**Subject:** Rezoning Petition Review

**From:** Doug Lozner

**Rezoning Petition #:** 21-221

**Location of Property:** Approximately 5.10 acres located on the west side of Statesville Rd, east of Millhaven Ln and south of Sunset Rd.

6 PROPOSED SITE PLAN
SCALE: 1"=50'-0"

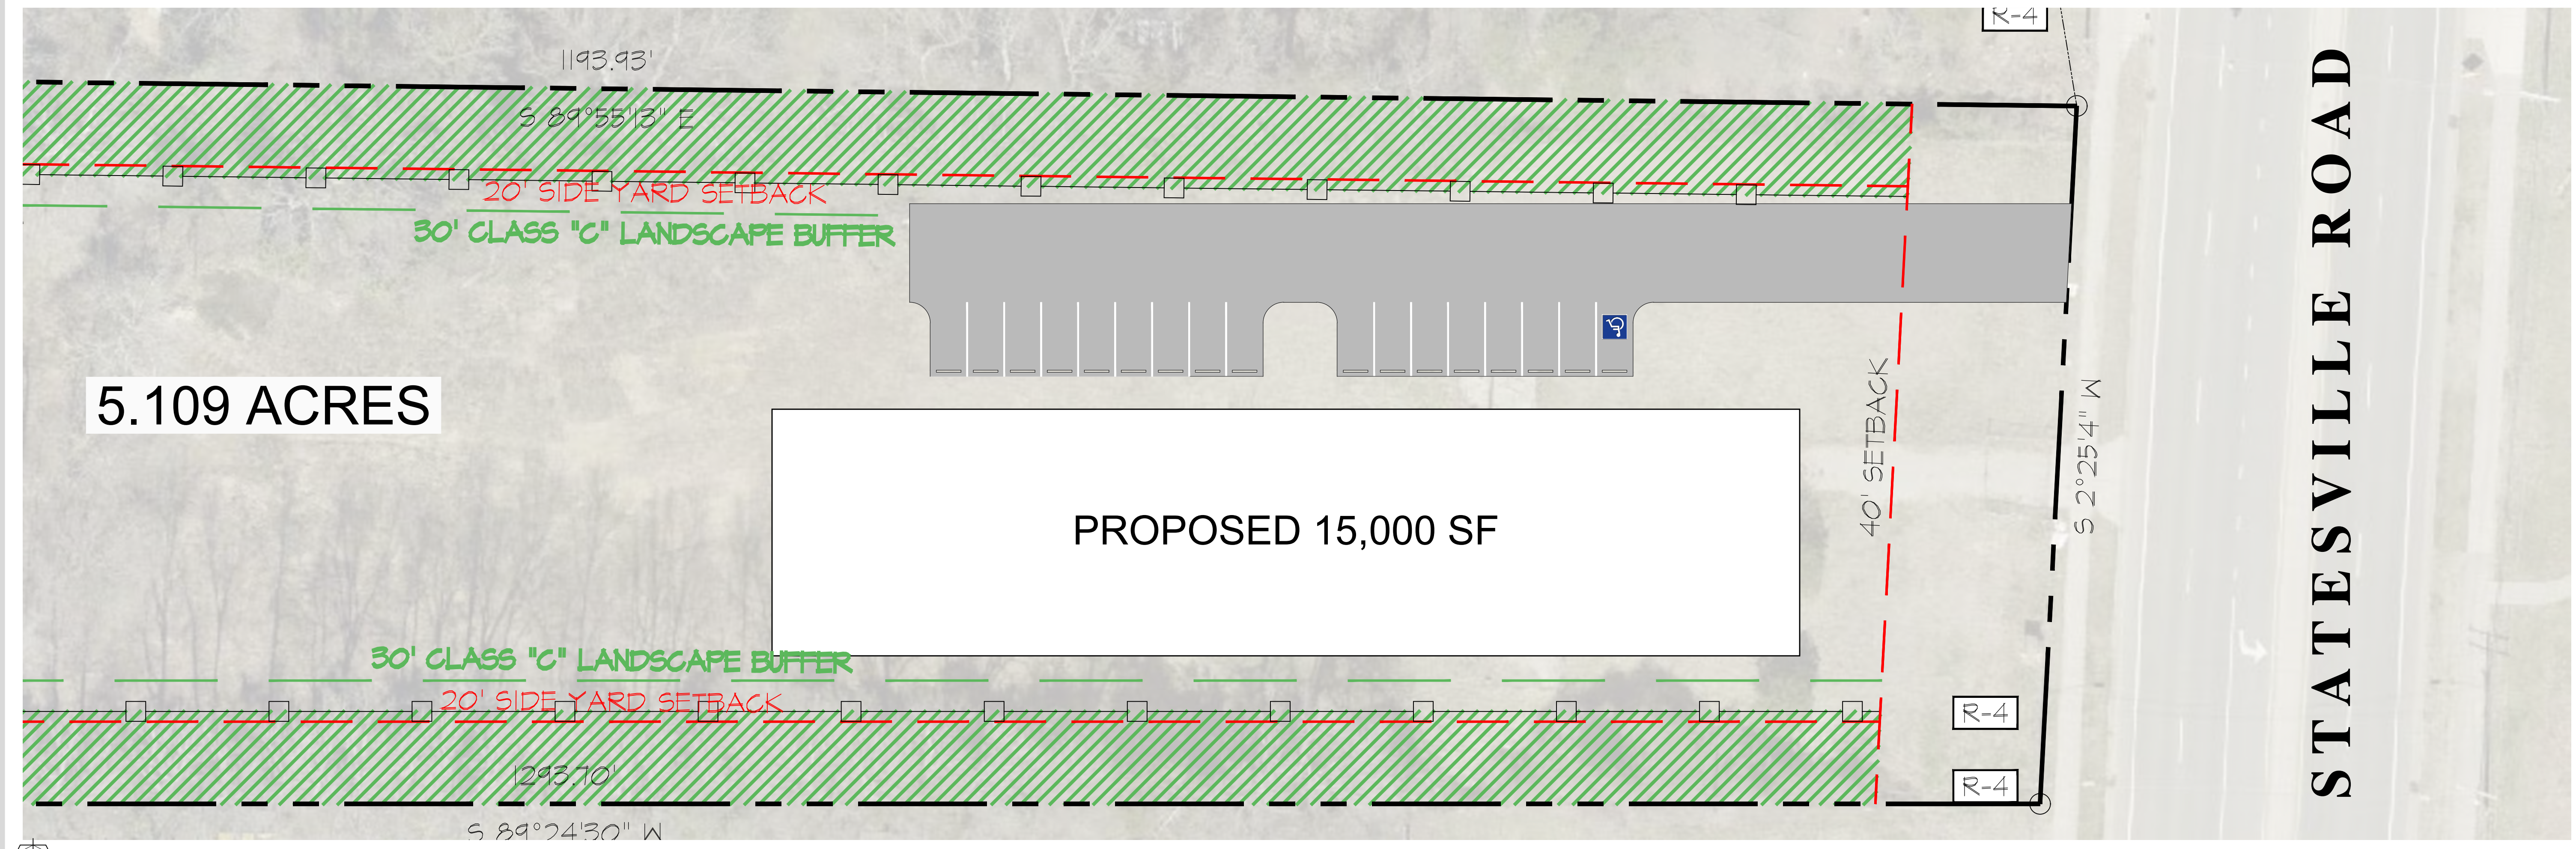
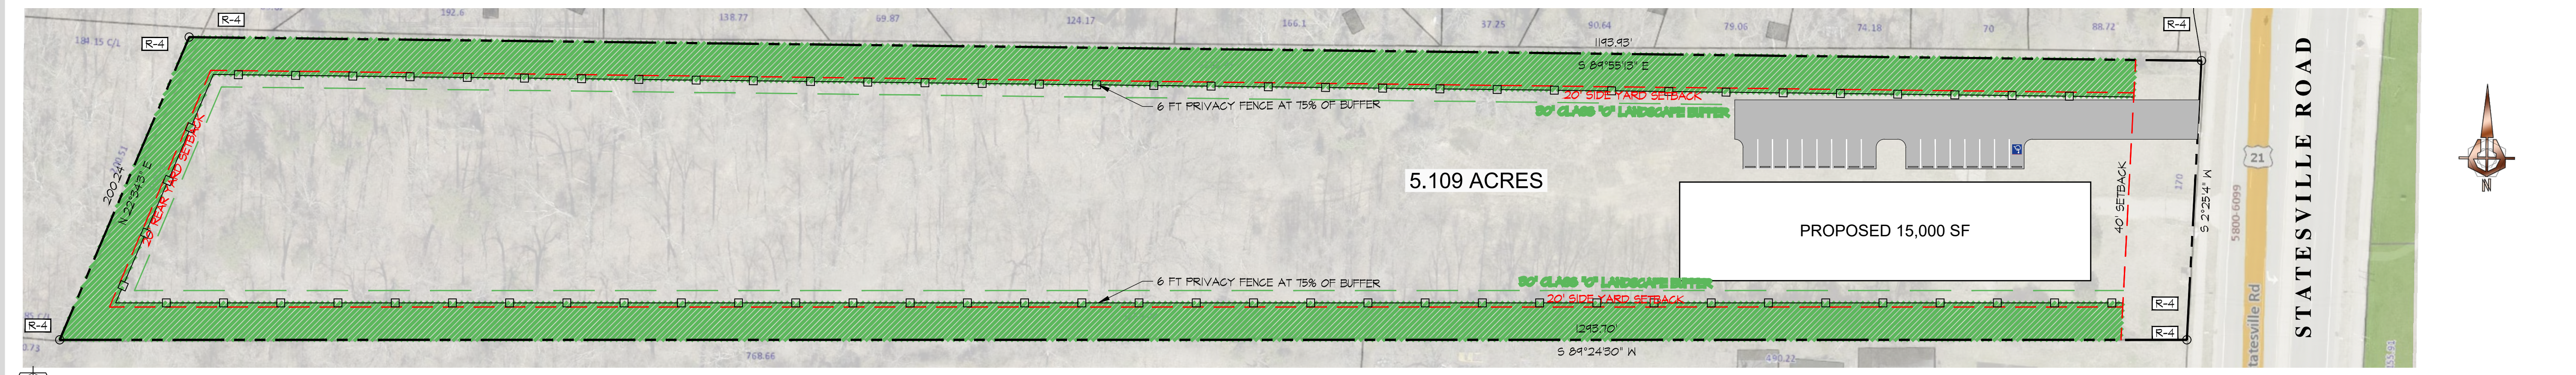
City of Charlotte GIS data indicates a 30-ft PCSO buffer across the site. Please show and label *Potential 30-ft PCSO Buffer* on the site plan. Any increase of impervious area within such buffers may not be allowed and is not approved with the rezoning process. Please include the following note under Environmental Features: *“Development within any SWIM/PCSO Buffer shall be coordinated with and subject to approval by Charlotte-Mecklenburg Storm Water Services and mitigated if required by City ordinance. Petitioner acknowledges intermittent/perennial stream delineation reports are subject to review and approval upon submission of development plans for permitting and are not approved with rezoning decisions.”*

Advisory note: Charlotte-Mecklenburg Storm Water Services has a 20-ft wide drainage easement on the site (reference DB11413 PG851). No permanent structures are allowed over or across this easement.

**This property drains to Irwin Creek, which is an impaired/degraded stream, and may contribute to downstream flooding. This project has the opportunity to mitigate future impacts to this stream, therefore, Storm Water recommends placing the following notes on the plan:**

For defined watersheds greater than 24% built-upon area (BUA), construct water quality stormwater control measures (SCMs) designed for the runoff generated from the first 1-inch of rainfall for all new and redeveloped BUA associated with the project. SCMs must be designed and constructed in accordance with the Charlotte-Mecklenburg BMP Design Manual.

For defined watersheds greater than 24% built-upon area, control the entire volume for the 1-year, 24-hour storm for all new and redeveloped BUA associated with the project. Runoff volume drawdown time shall be in accordance with the Charlotte-Mecklenburg BMP Design Manual.

For commercial projects with greater than 24% BUA, control the peak to not exceed the predevelopment runoff rates for the 10-yr, 6-hr storm and perform a downstream flood analysis to determine whether additional peak control is needed and if so, for what level of storm frequency, or if a downstream analysis is not performed, control the peak for the 10-yr and 25-yr, 6-hour storms.

For residential projects with greater than 24% BUA, control the peak to not exceed the predevelopment runoff rates for the 10-year and 25-year, 6-hour storms or perform a downstream analysis to determine whether peak control is needed, and if so, for what level of storm frequency.
